12 December 2024

SSD-61000021 – Objection – 146 Arthur St, North Sydney - Build-to-Rent

1 Overall Elevation - North
SCALE 1 : 500

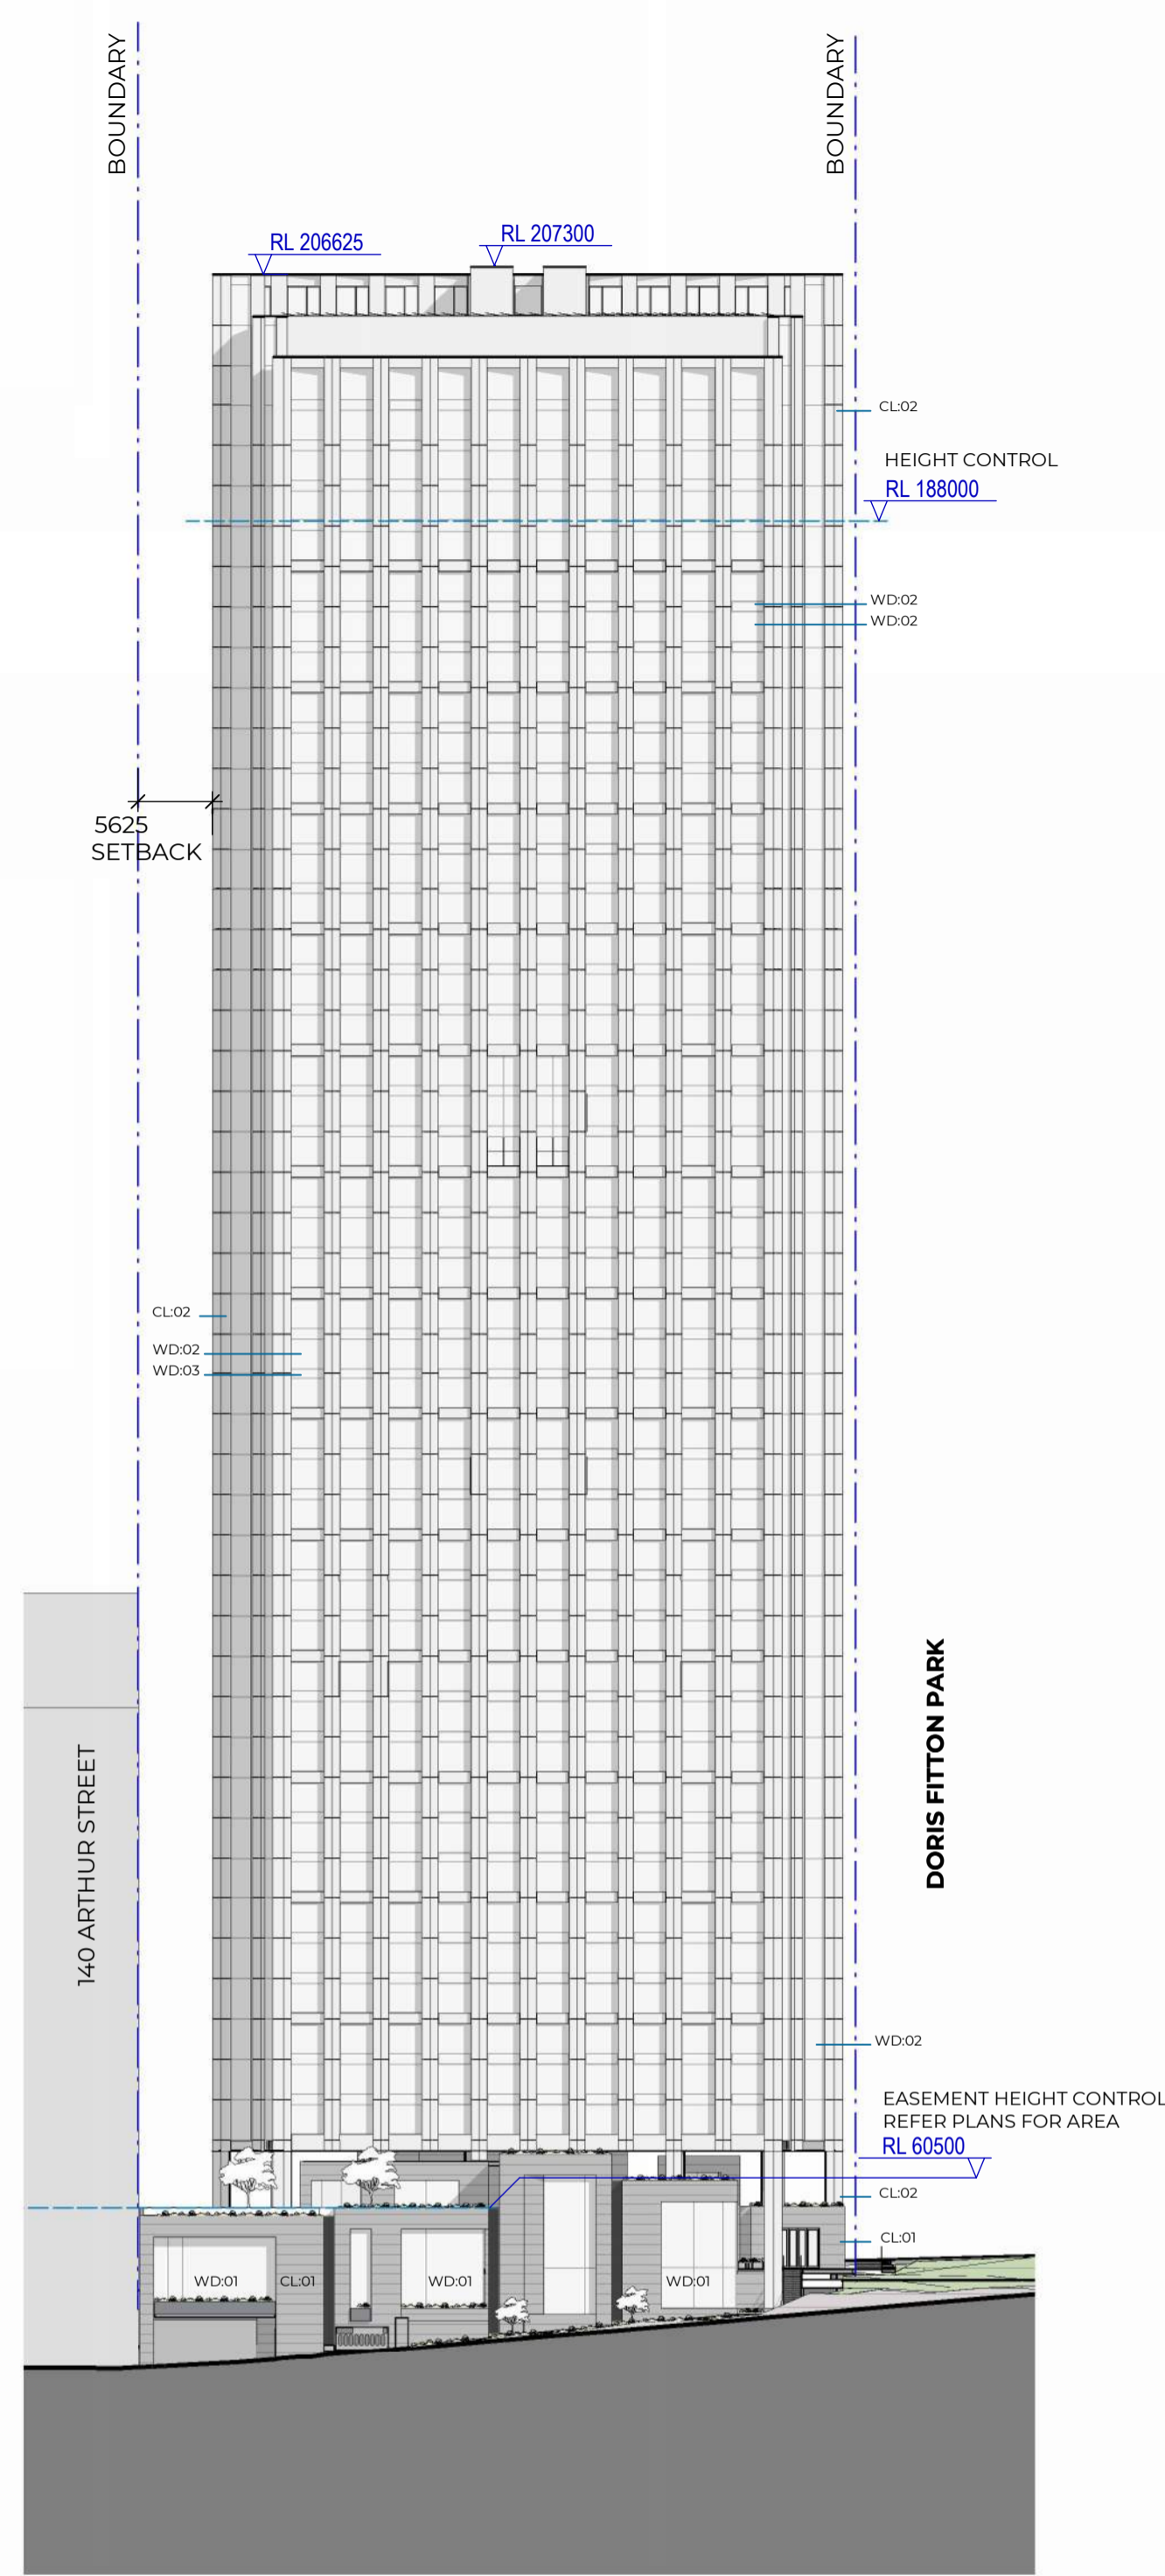
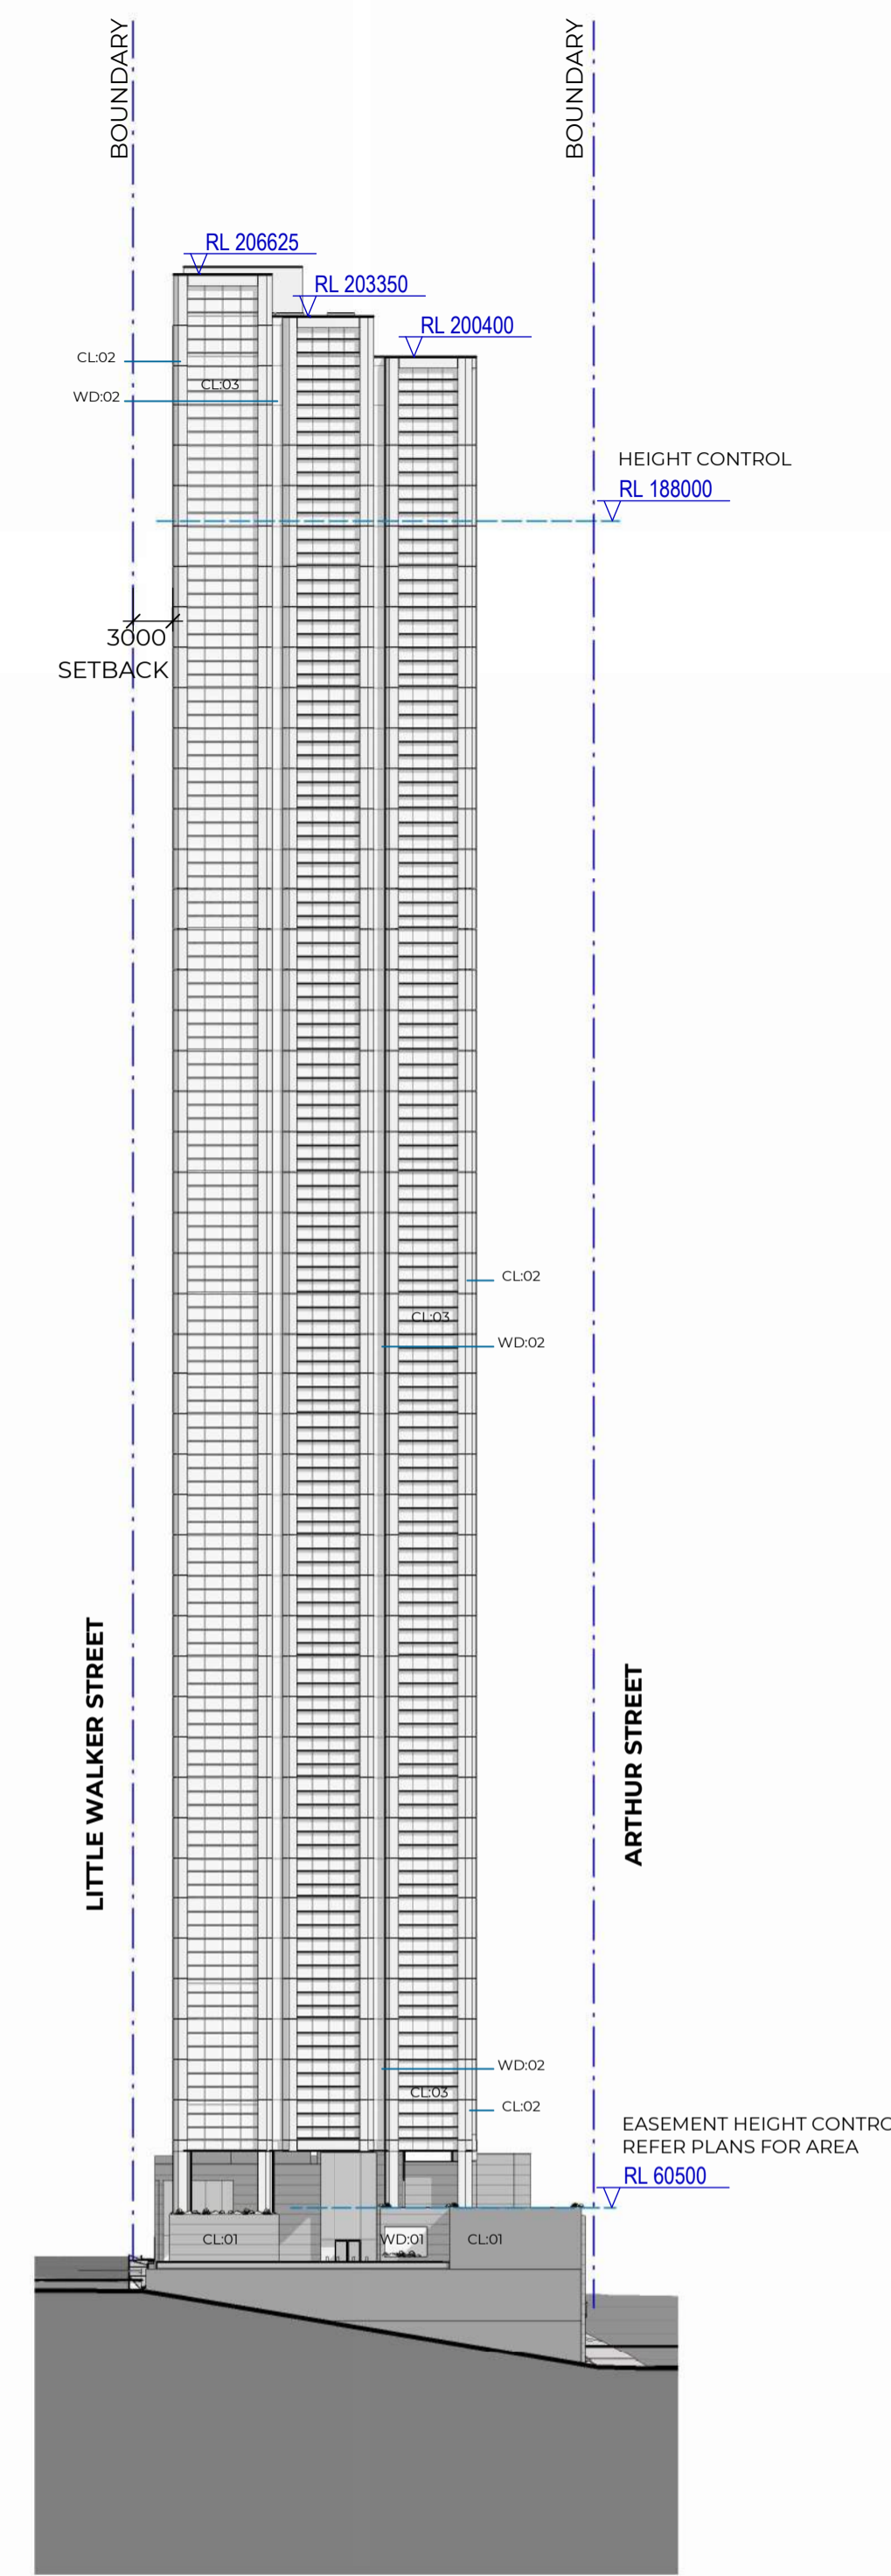
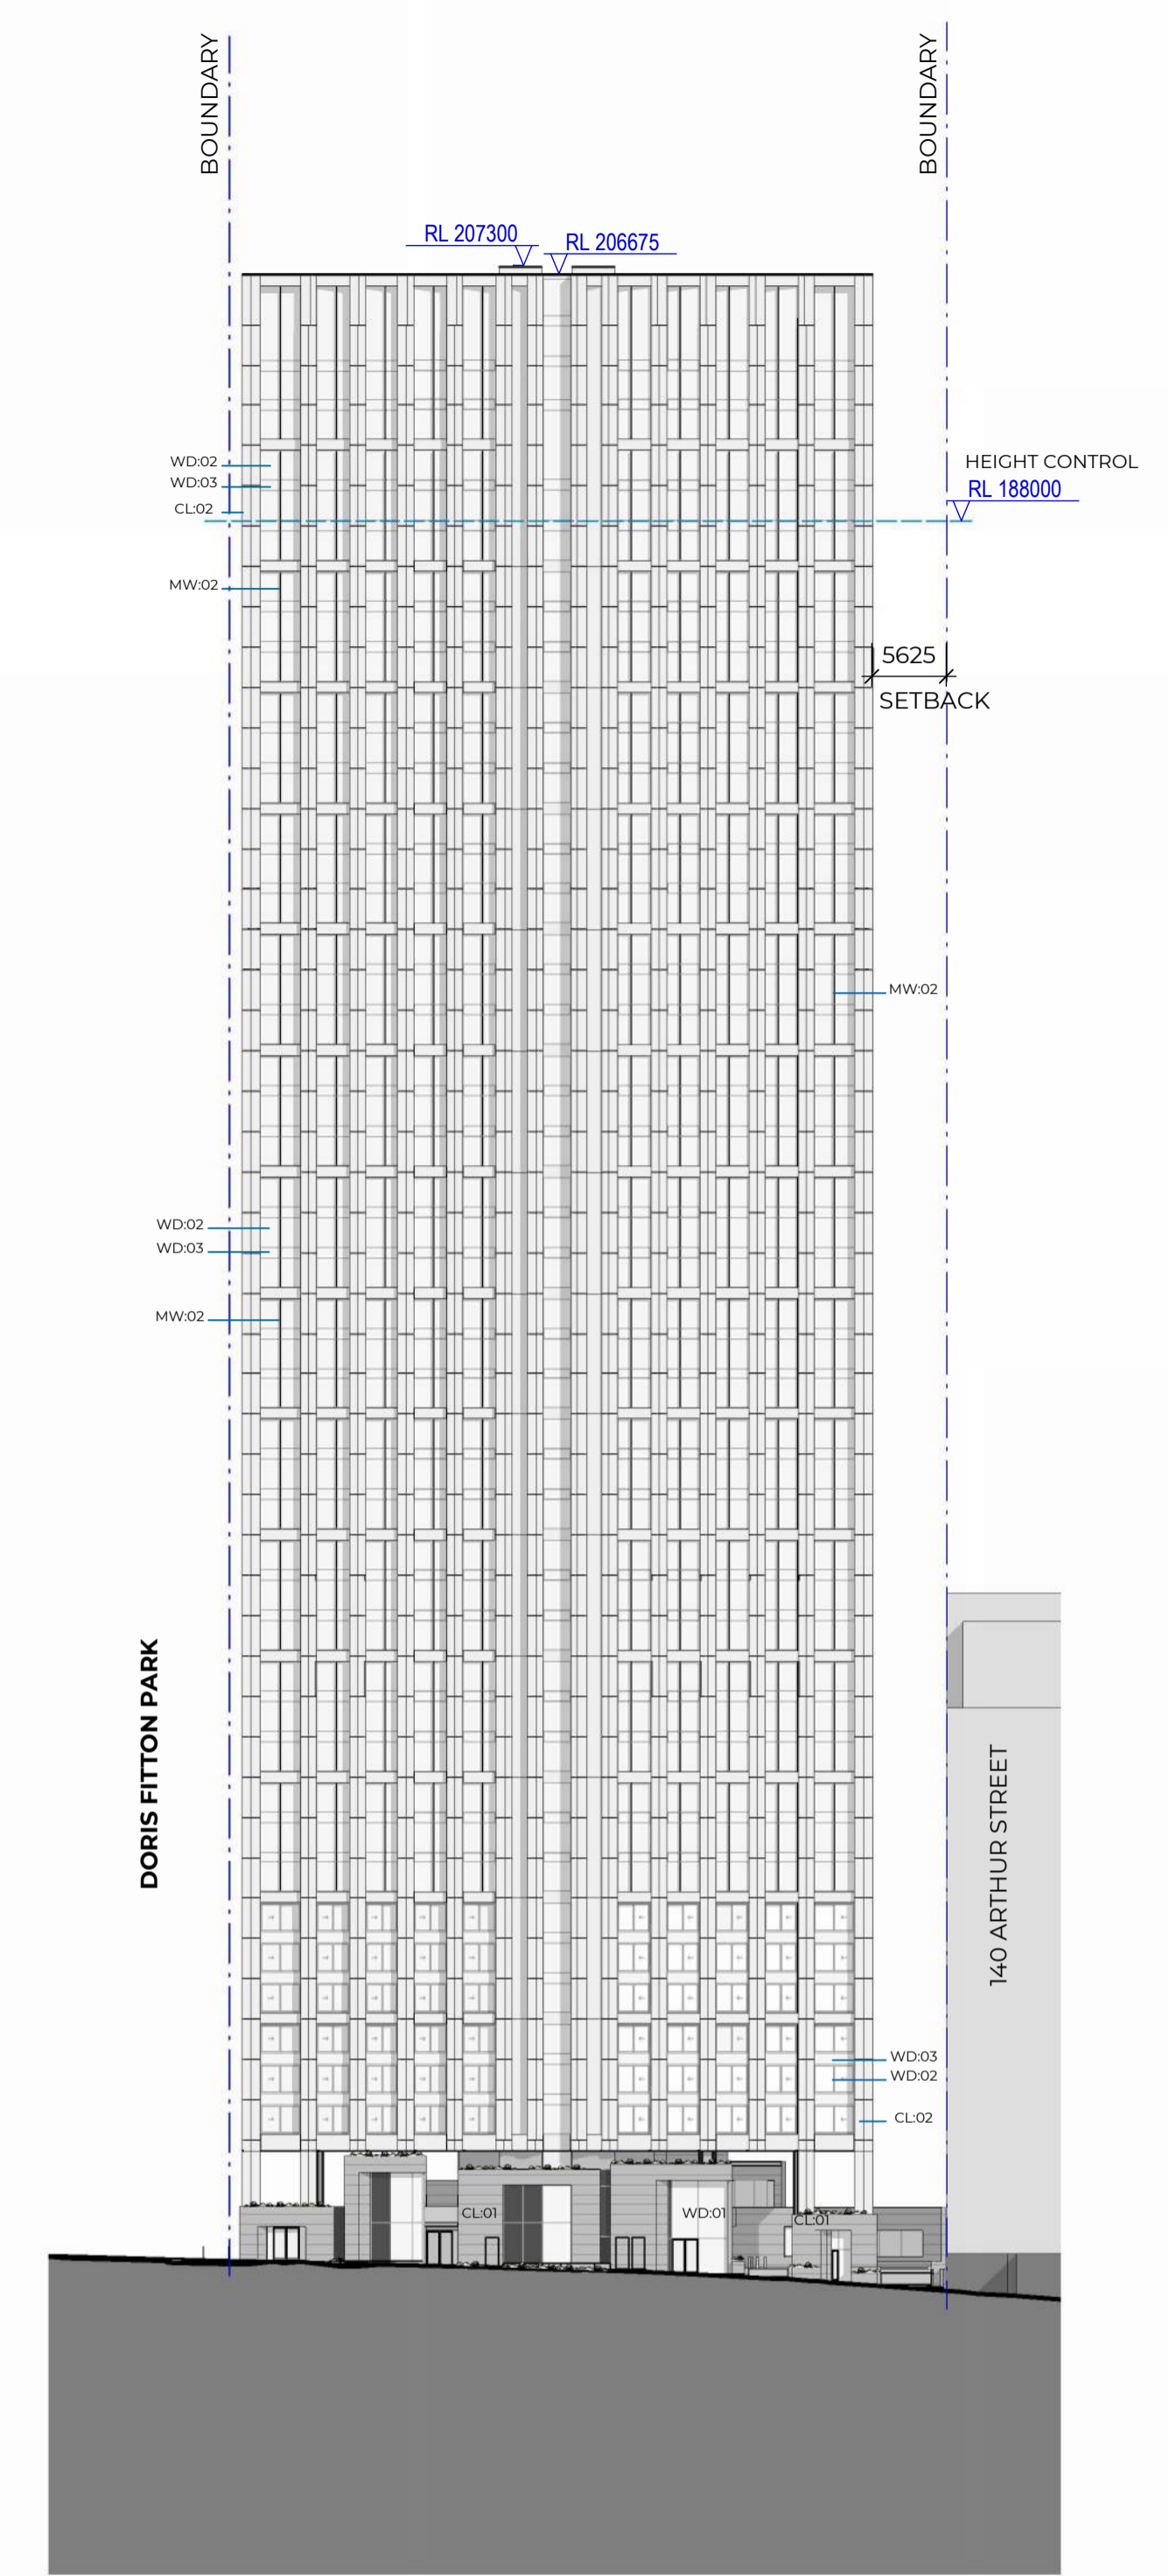
The Proposed Development exceeds the maximum permitted building height by 19.3m, or 10.27% of the standard to be varied. The proponent relies on clause 6.3 of the *North Sydney Local Environmental Plan 2013 (LEP)*. This exceedance will cause the loss of considerable views from the east-facing residences of the proposed development of the Freecity Property. These views are highly significant, to which our client raises the following concerns:

The EIS underscores that the proposed design is consistent with the 'commercial appearance' of the surrounding North Sydney CBD. While this contextual consideration is appropriate to recognise in the context of North Sydney, the EIS' heavy reliance on this point, only when it benefits the Applicant, is a substantial conflict given the scheme's failure to adhere to the intended 4m above-podium average weighted setback from Little Walker Street.

Appendix 3 (Statutory Compliance Assessment) of the SSDA provides a poor justification for a 2.4m above-podium setback from Little Walker Street instead of the preferred 4m, citing site constraints that would allegedly affect the building's structural integrity and internal amenities. This reasoning does not consider the context-based arguments presented in the Clause 4.6 Variation Request regarding the prevailing scale of development in the area, which is generally expected to comply with the setback provisions

The perceived scale of development from Doris Fitton Park will be particularly pronounced at specific points along the frontage. Notably, the tower setback from Doris Fitton Park diminishes to a mere 1m towards the corner of Little Walker Street and Doris Fitton Park.

The Proposed Development's western façade is unarticulated. It contains no angulation and proposes to rely on vertical aluminium fins that direct, rather than divert, views towards 153-157 Walker Street. This is inappropriate if 153-157 Walker Street was to be developed as a purely commercial scheme and it is unacceptably inappropriate where it is to be predominantly residential, as outlined in our client's Request for SEARs.

- a 4m above-podium average weighted tower setback must be adopted along Little Walker Street;
- a 6m setback to Doris Fitton Park must be adopted. At minimum, this must be implemented in relation to the north-western aspect of the proposed tower form; and
- in the absence of sufficient environmental planning grounds to support the proposed height variation, the height of the proposal should be reduced to satisfy clause 4.3 of the LEP.
